From: Ed Sewall <esewall@sewallwc.com>
Sent: Wednesday, December 3, 2025 8:52 AM
To: chrisimmer islandchapel.net
Cc: Bradley Gasawski
Subject: Immer site plan
Attachments: immer wetland buffer sketch.png

Chris and Bradley, this email (below) is a follow up to the question about how much of the site is wetland buffer and how much of the site is stream buffer.

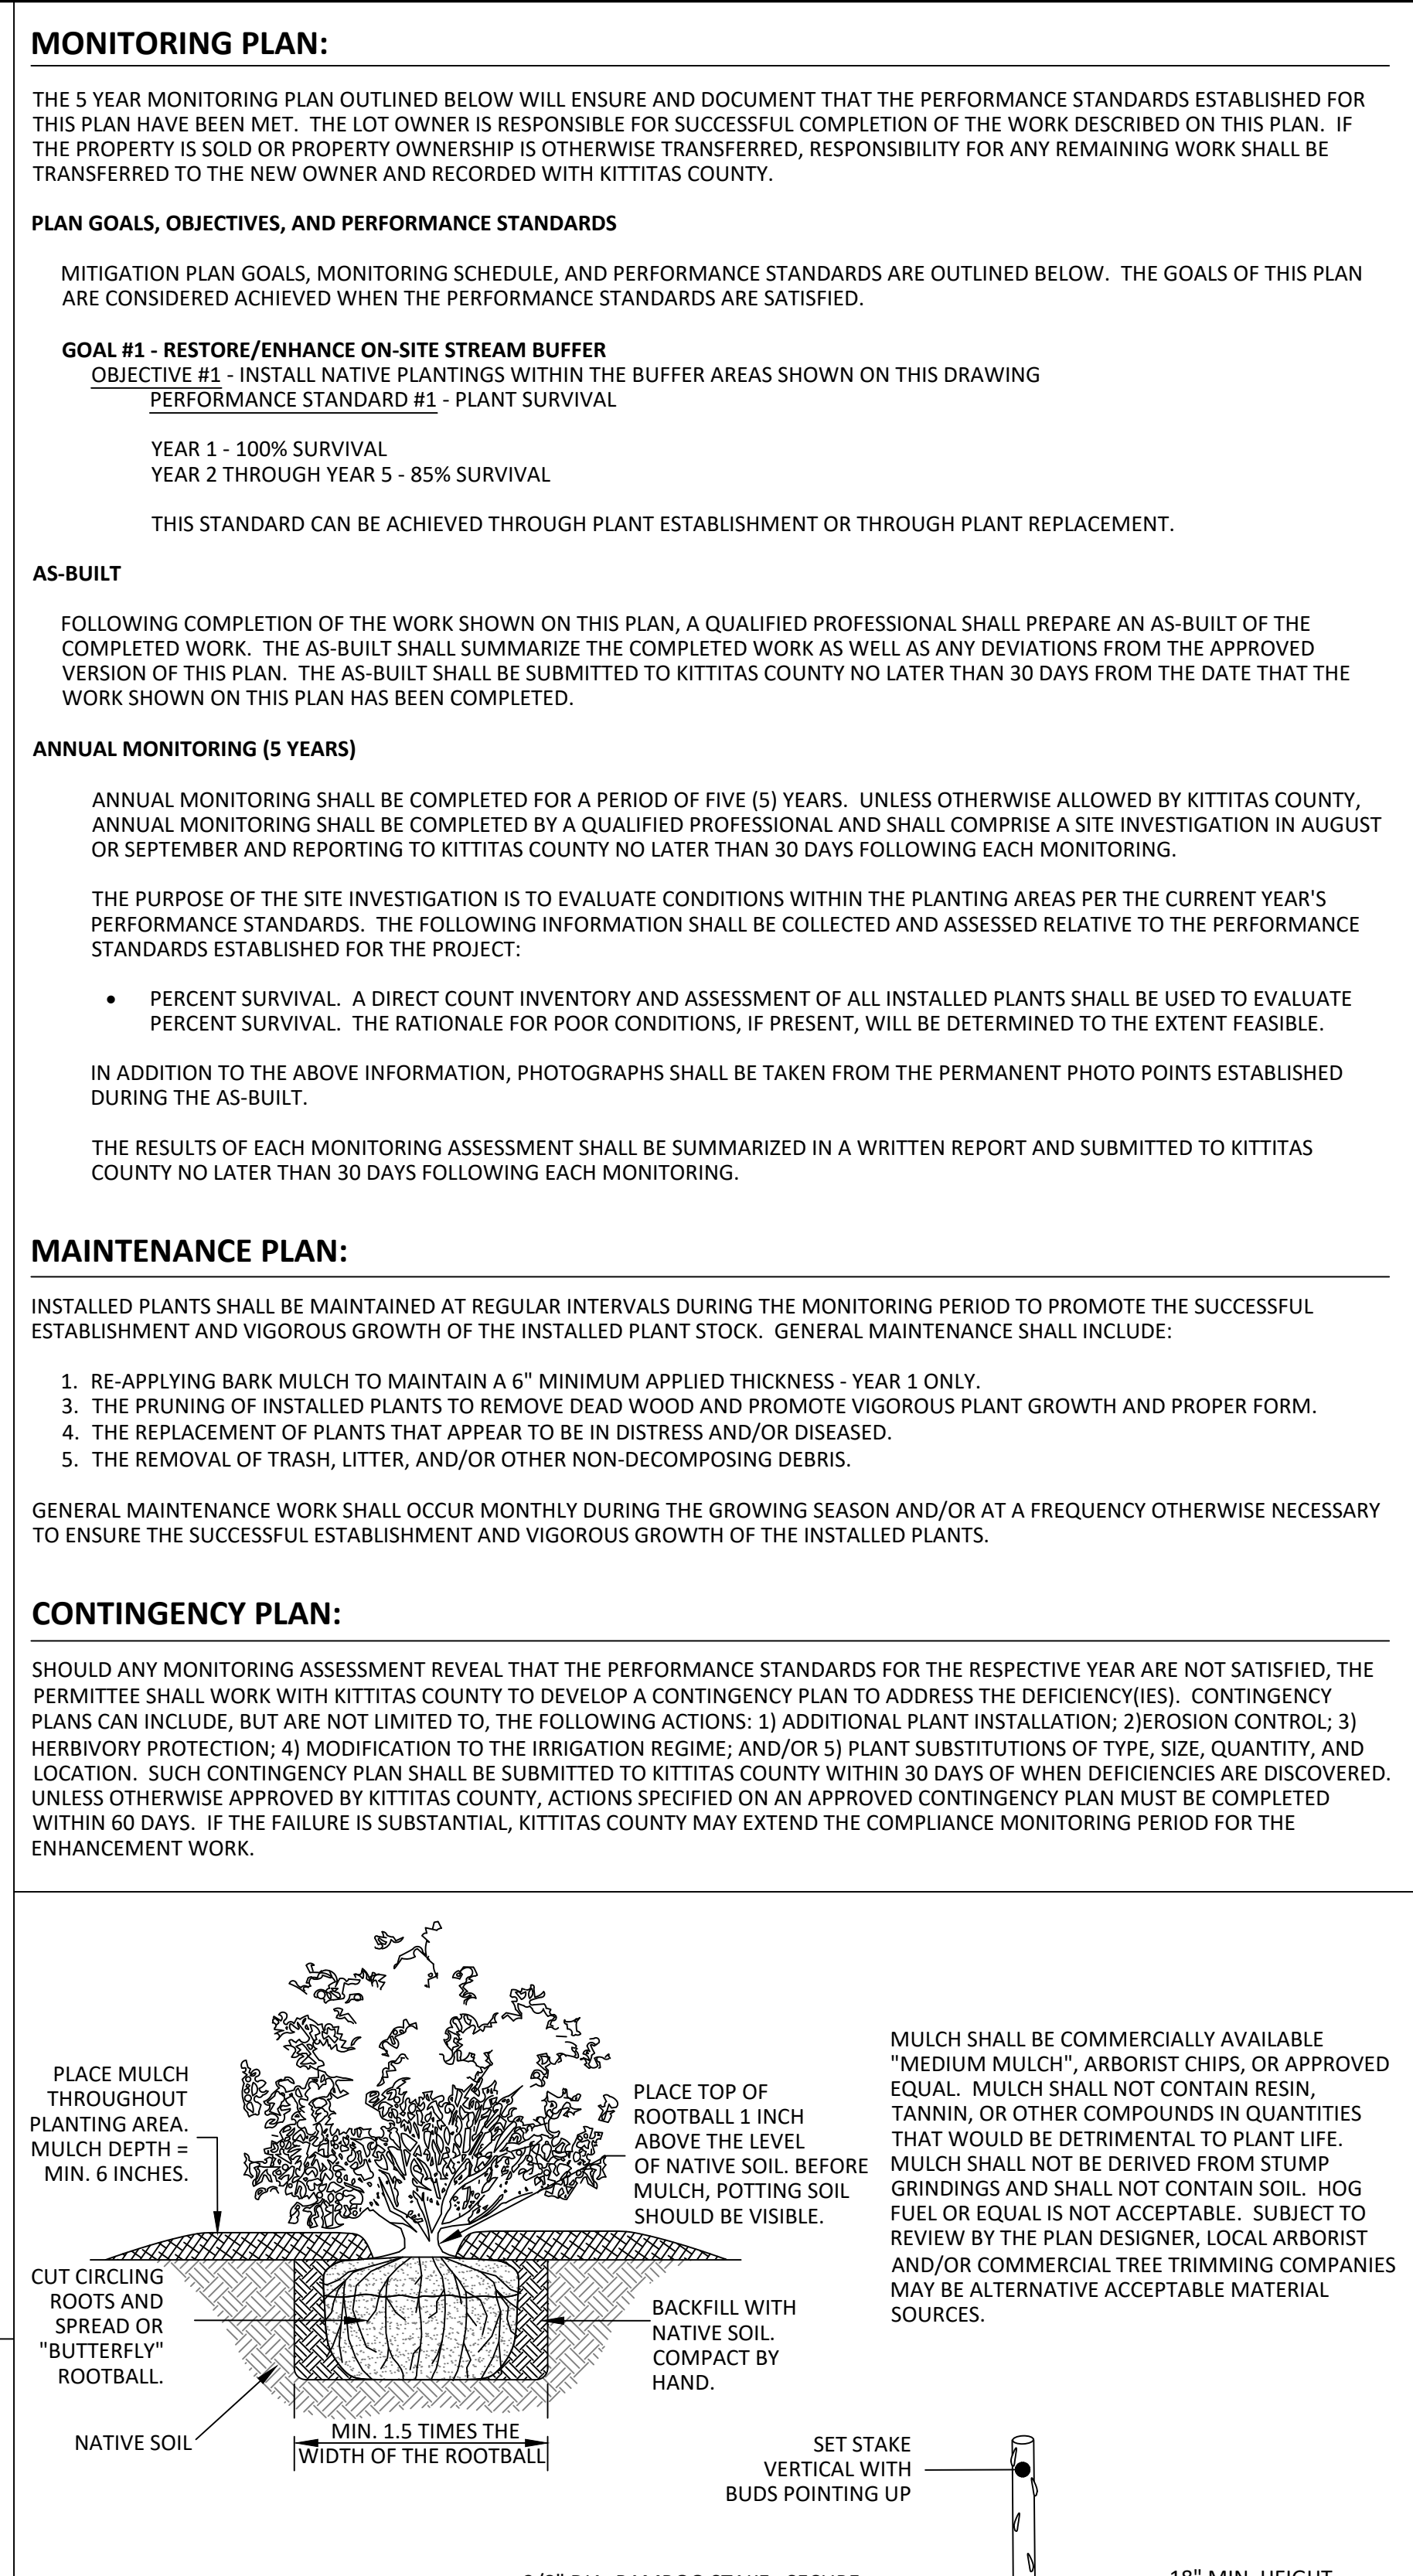
Thanks for the follow up email. The mitigation document is a big step forward. Thank you for working with Ed on this plan. There is a lot of good information in the mitigation plan and the site plan. We are also looking for you and/or Ed to identify the extent of the wetland buffer on your parcel. We know the stream buffer encompasses your entire parcel, but we need you to show the wetland buffer and include the square footage of the wetland buffer being impacted as your proposal is drawn. As we discussed, this would give us accurate information so that we can determine the amount of square footage needed as part of the mitigation plan. Without, it will be tough for us to determine the amount of mitigation area needed to account for the loss of buffer habitat because of the proposed project.
